RE 43 SEA LANE - CARAVAN/ CARPORT

Objection to Planning Application EP/23/19/HH at 43 Sea Lane for Caravan/Car Port.

Proposed Car/Caravan port
 43, Sea Lane , East Preston
 BN16 1NE
 Sheet 1
 Dimensions in mm
 Date- 19th February 2019
 Drawn- Paul Haymes

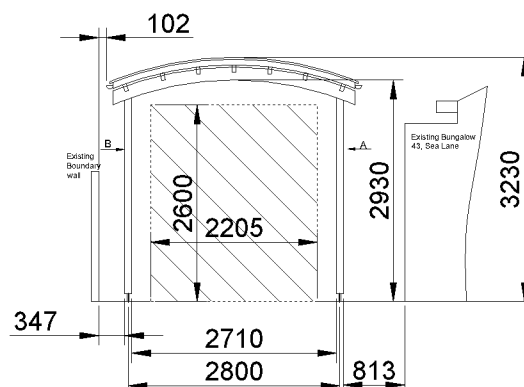
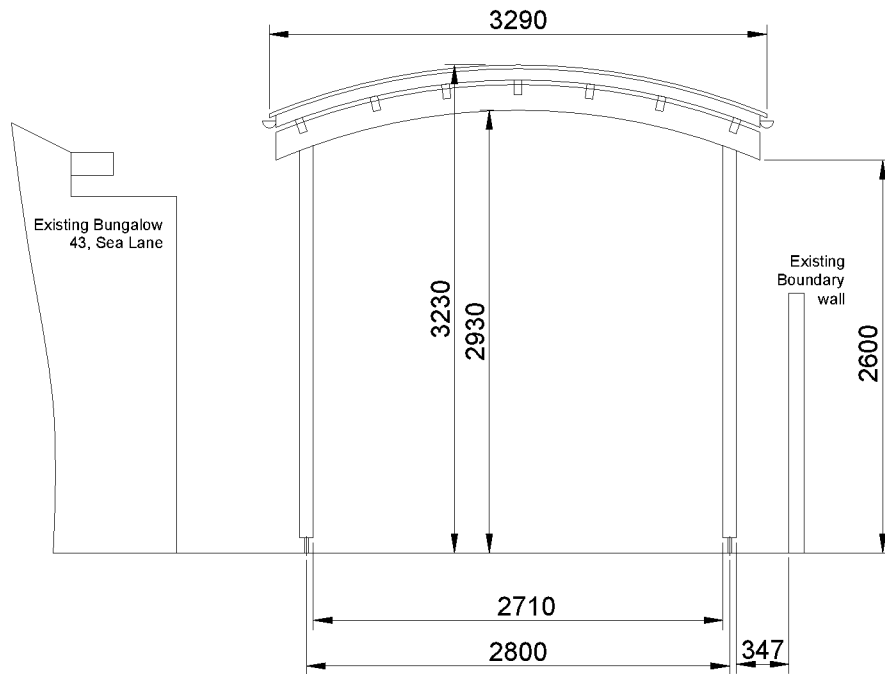
6. The proposed siting shows the pillars of the structure being too close to the party wall with 41 Sea Lane.
7. The proposed siting of the structure shows its roof edge being directly above the boundary wall between numbers 41 and 43 Sea Lane which is too close.

Proposed Car/Caravan port
 43, Sea Lane , East Preston
 BN16 1NE
 Sheet 2
 Dimensions in mm
 Date- 19th February
 Drawn- Paul Haymes

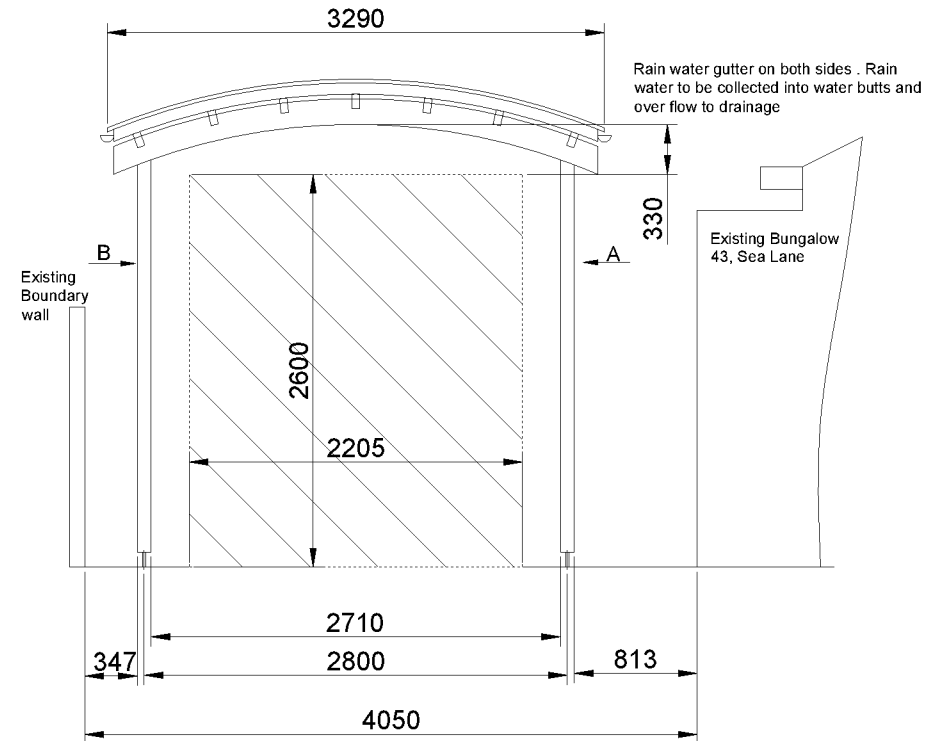
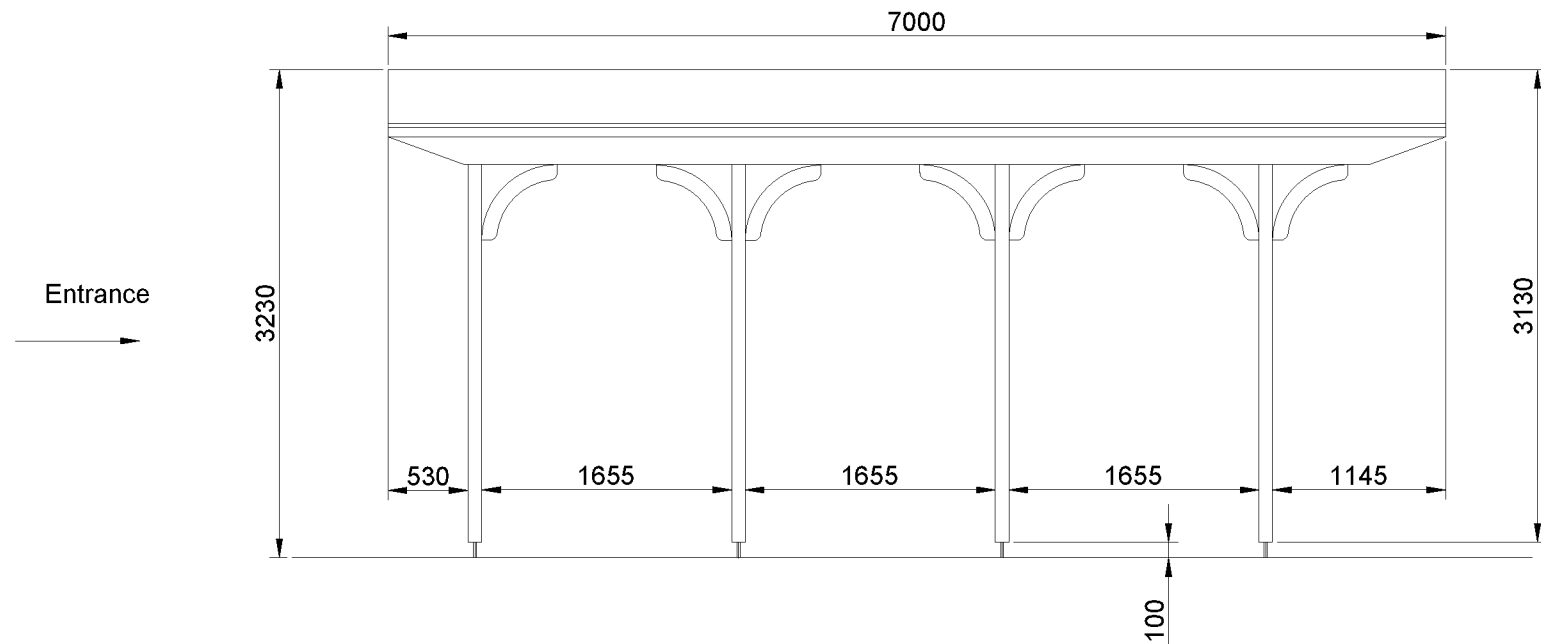
8. The proposed structure has a curved roof and any rainwater will run down directly onto the boundary wall and into the garden of 41 Sea Lane which is totally unacceptable.

9. It is not clear from the drawings of the structure whether there are gutters on either side of the roof. There is no apparent down pipe shown in the drawings so even if there are gutters there is no indication where the water will run off to. The drawings make reference to 'Jagram Tunbridge' structure and on closer inspection this does not have guttering.
10. The impact of the higher structure will have a significant loss on the level of sunlight on the area of 41 Sea Lane alongside the proposed structure and create a feeling of being hemmed in.
